CITY OF ALBUQUERQUE

**Re: BJ's Restaurant and Brewhouse Grading and Drainage Plan
Colleen Rezac Engineer's Stamp with No Date (B14D004E)**

Based upon the information provided in your submittal received June 25, 2014, the above referenced plan is approved for Site Plan for Building Permit action by the DRB.

PRELIMINARY GRADING PLAN

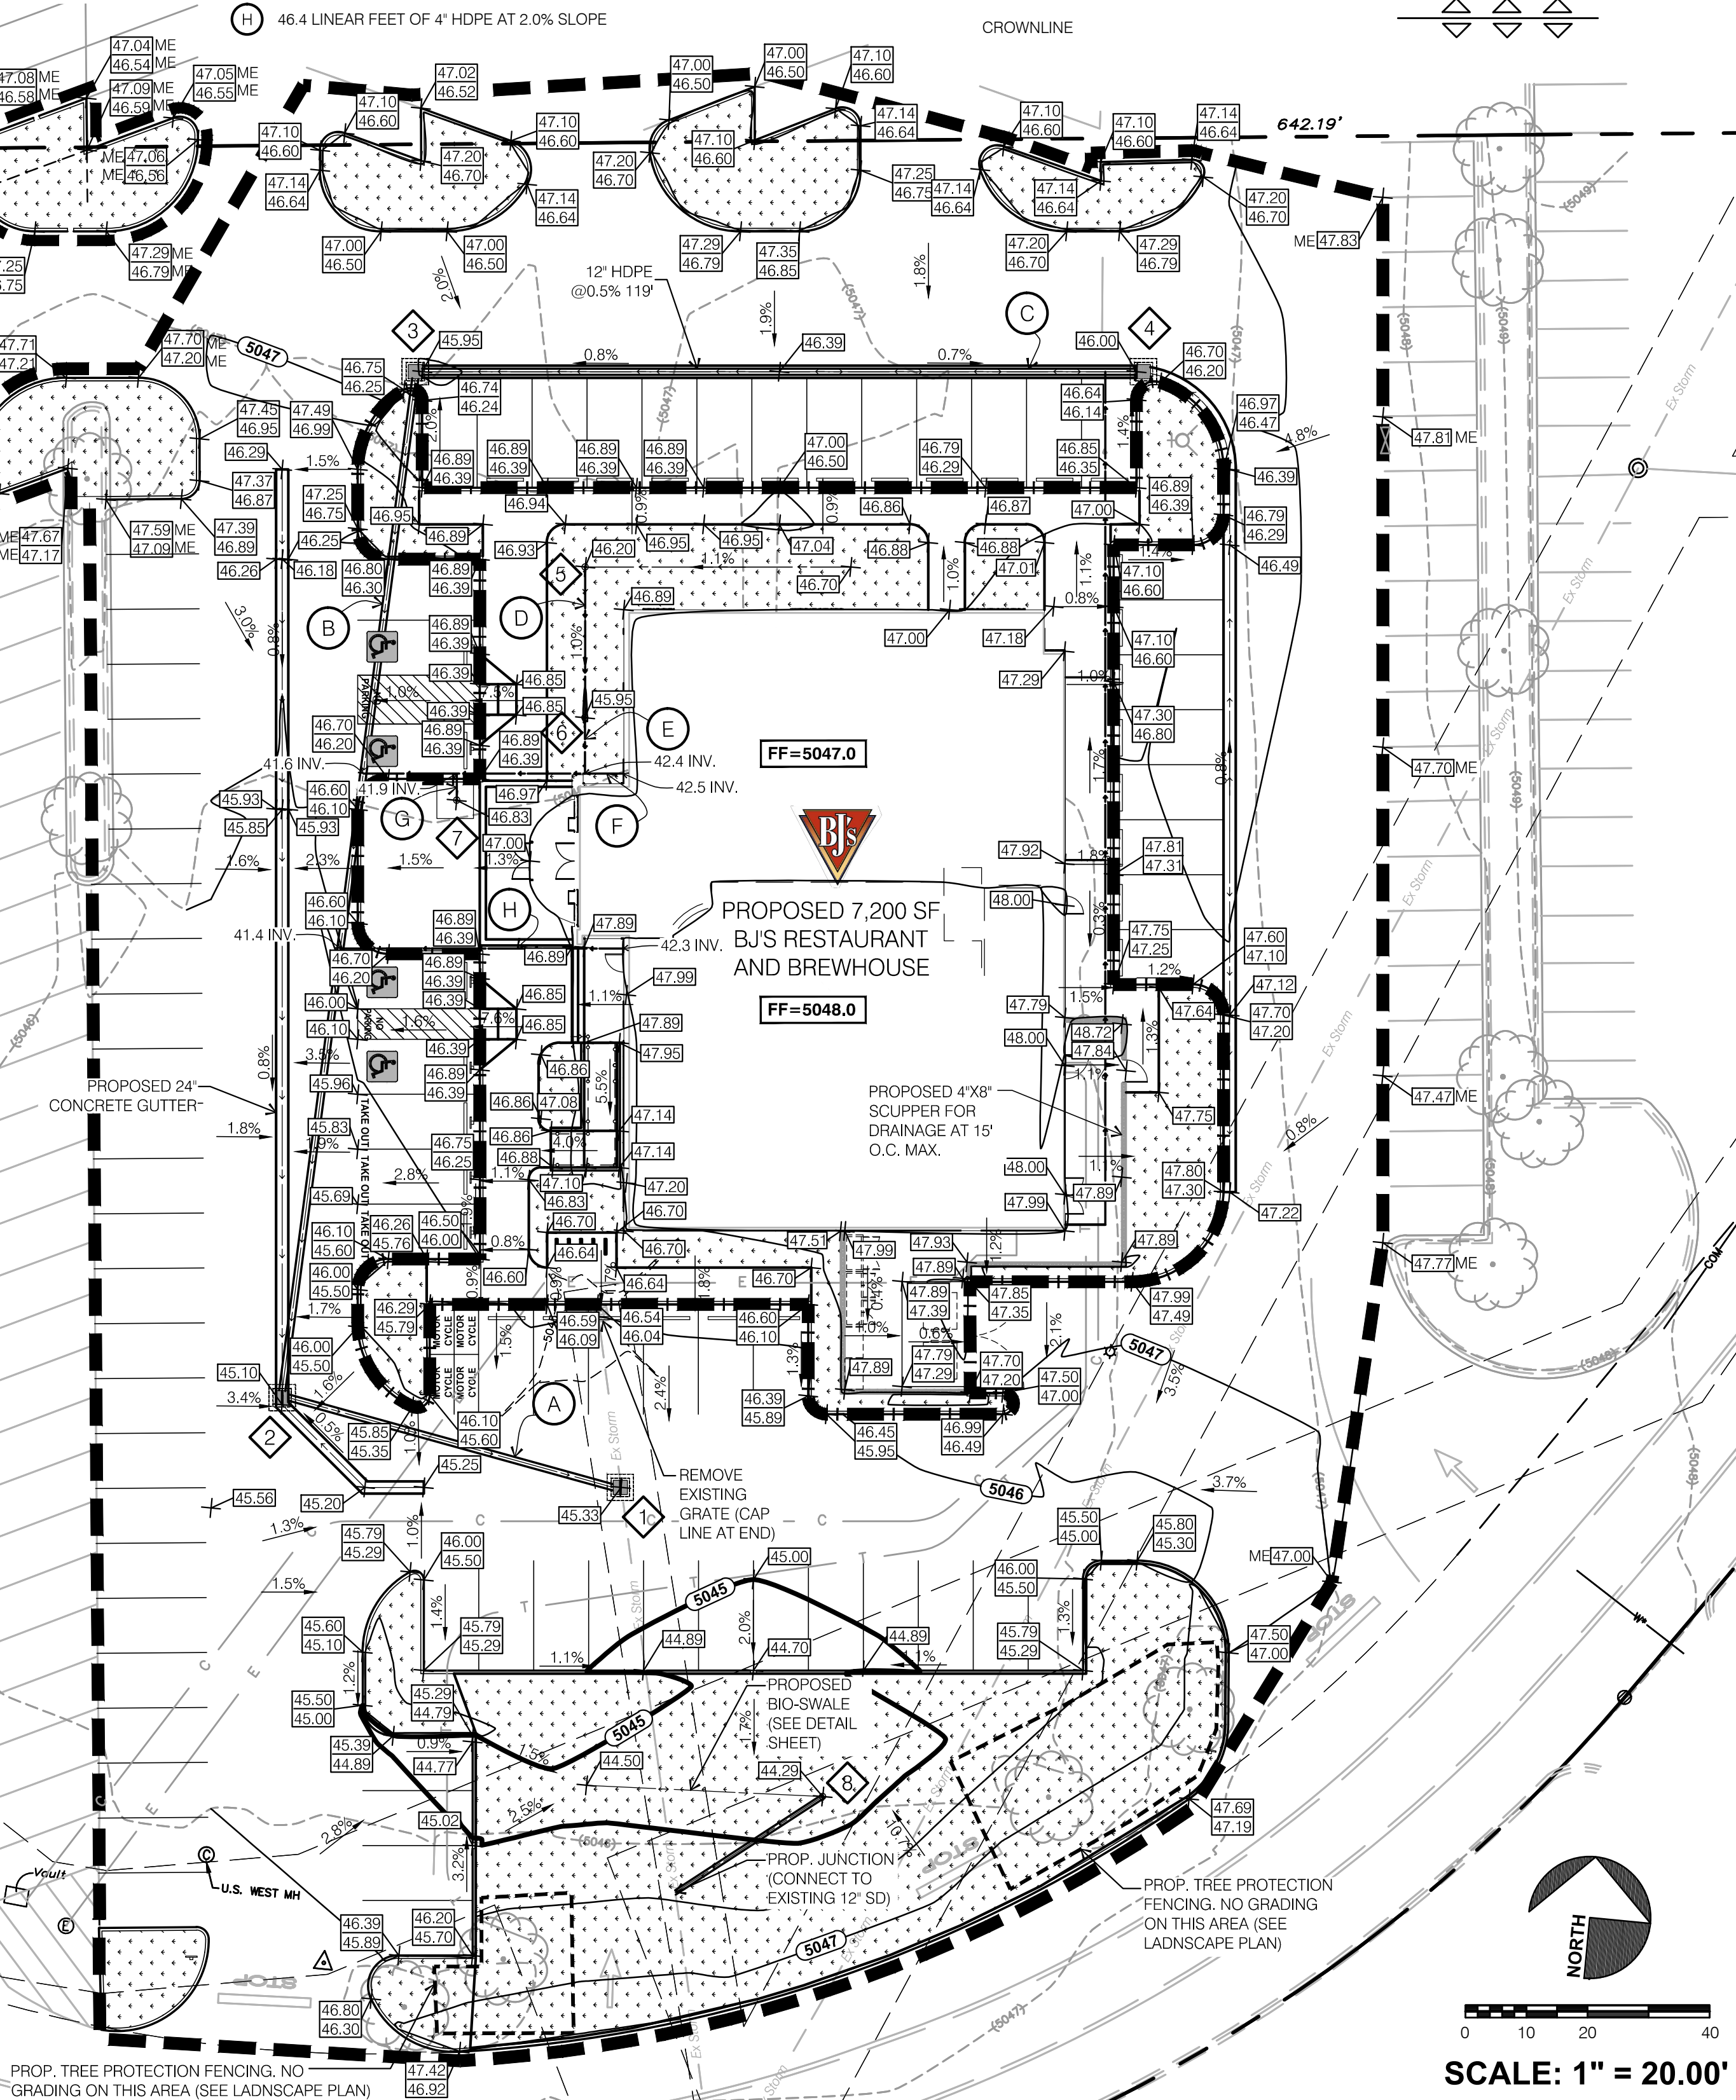
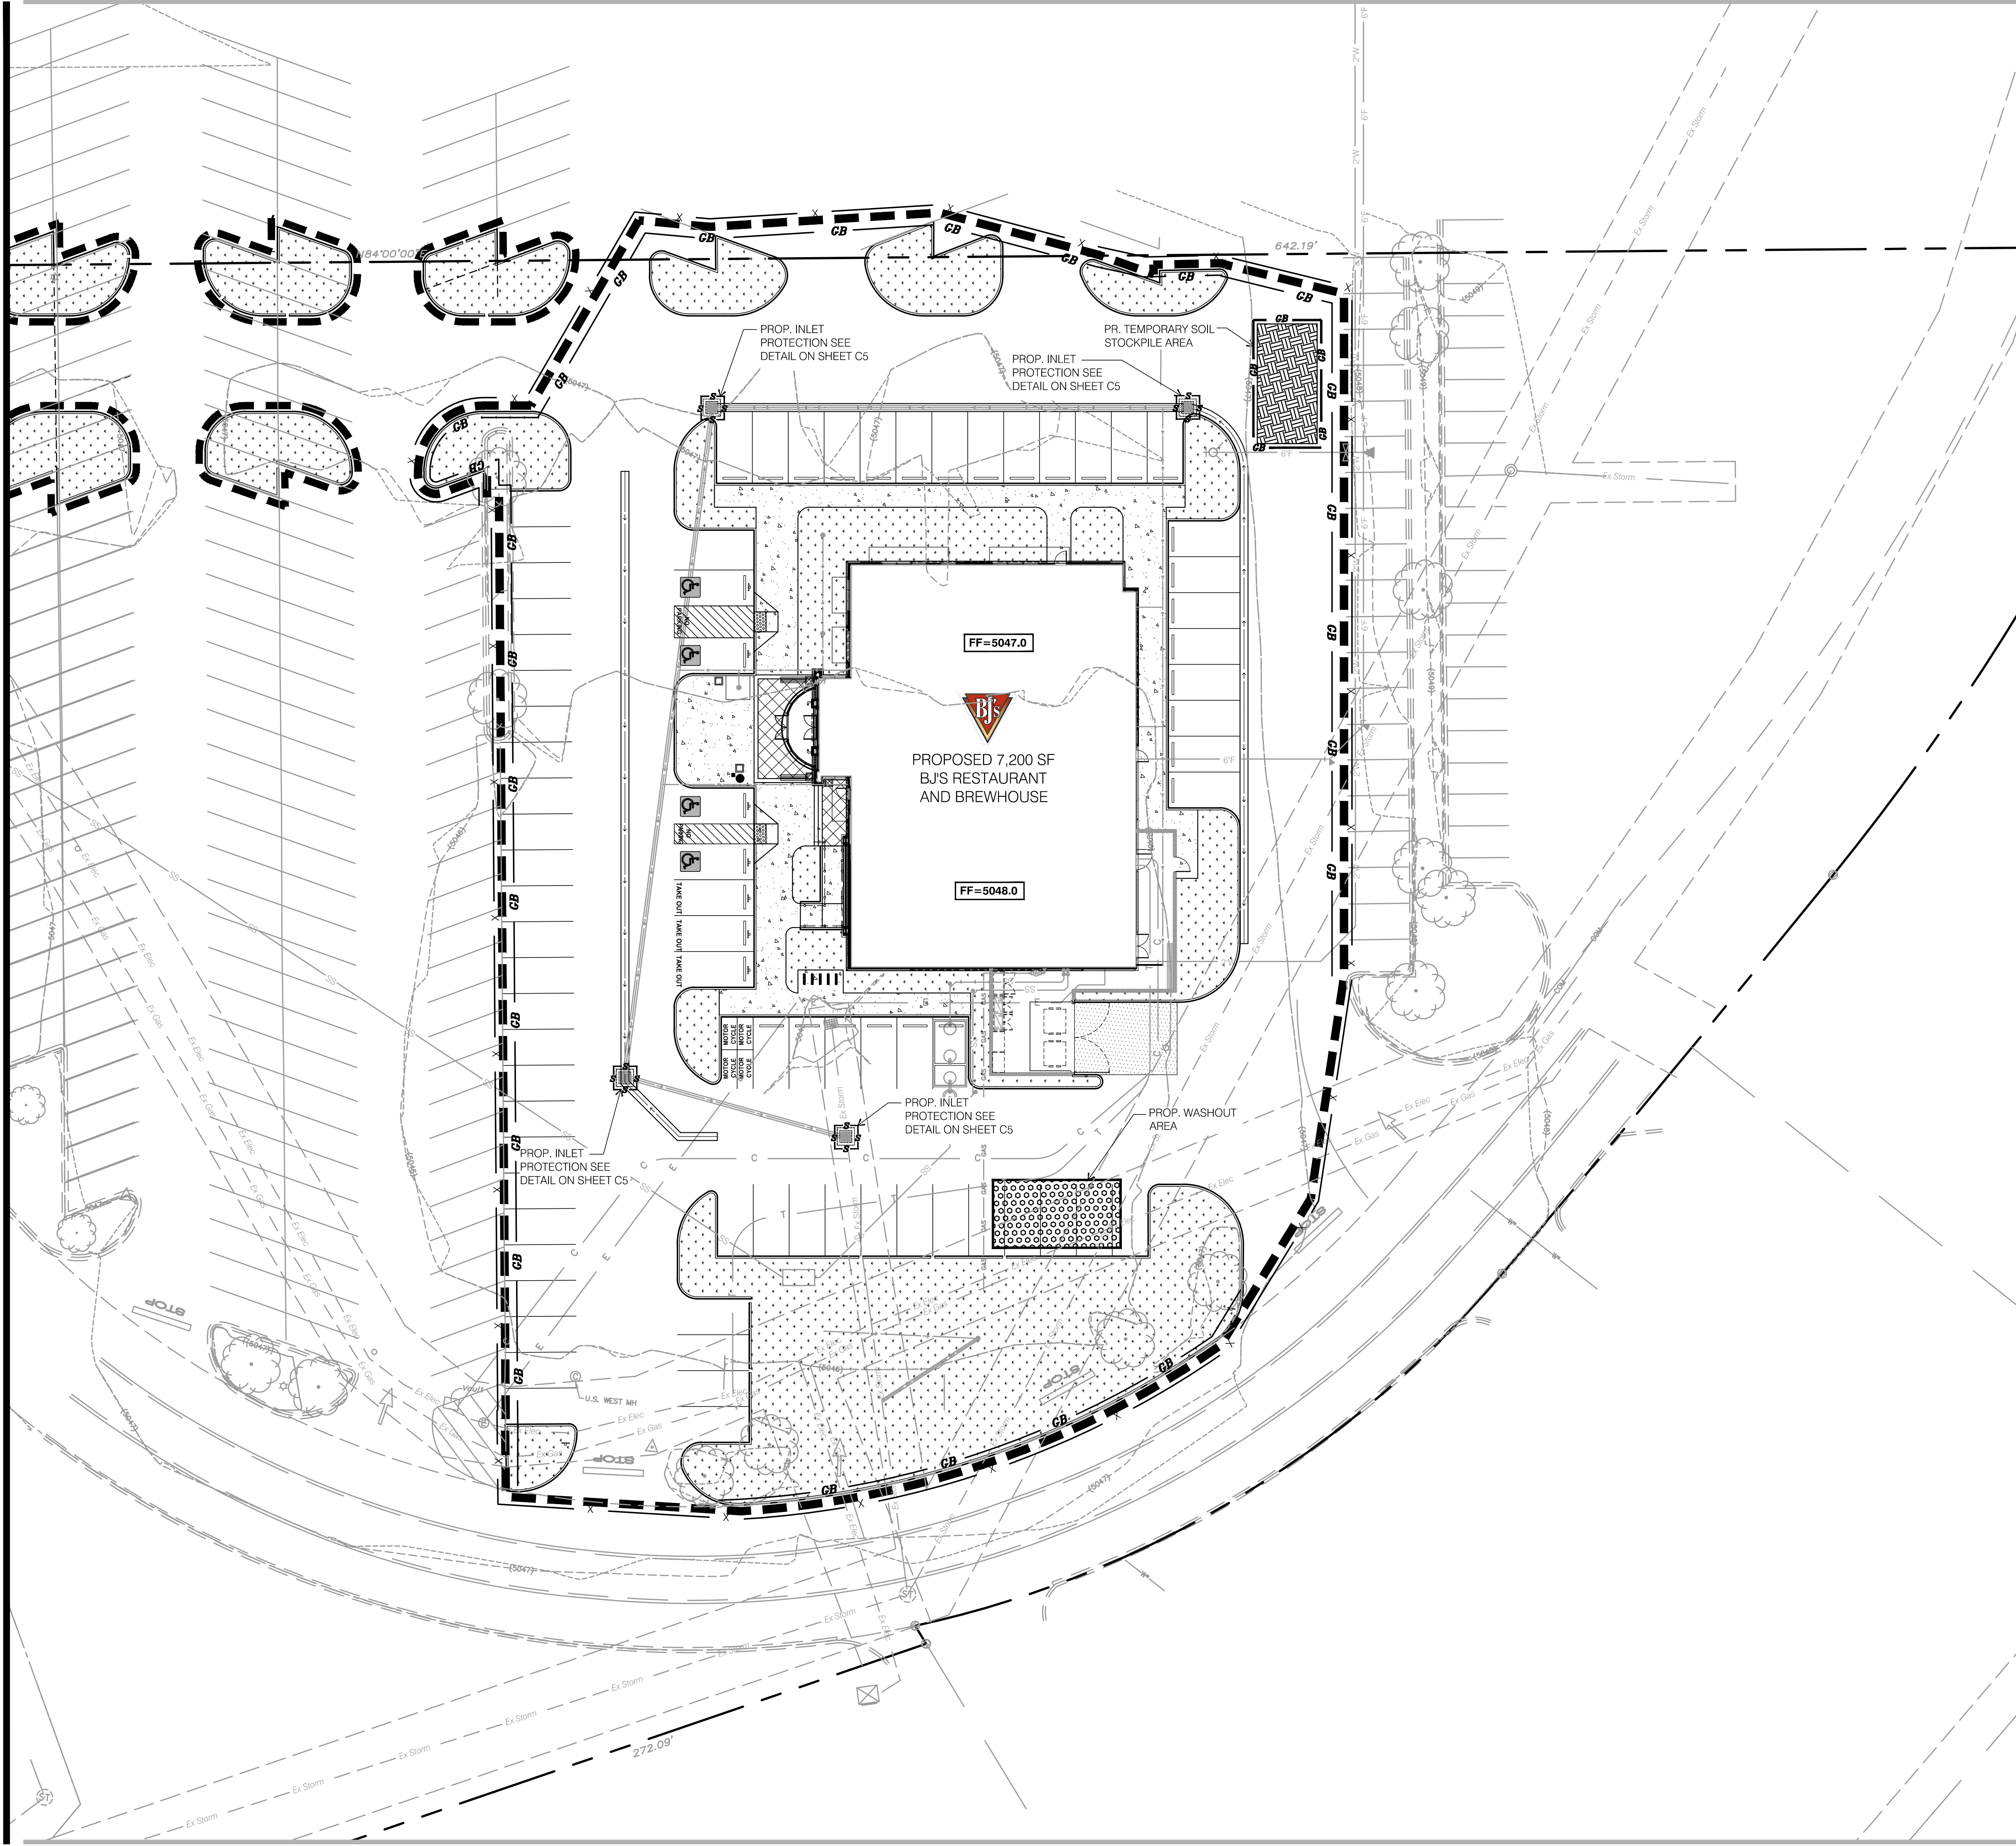
1. Schedule Note C states the storm pipe is 12 inch, but Schedule Note 4 calls out a 4 inch invert. Revise Note 4. Provide a call out for Schedule Note 8 and size of pipe. Call out a transition for connecting HDPE to concrete pipe.

4. No bio-swale detail is provided as has been called out. Provide the detail.
5. Include openings in all the islands for drainage to enter.
6. Plan note 2 calls for utilities to be relocated to the proposed grade. Be specific about which utilities and how they will be handled.
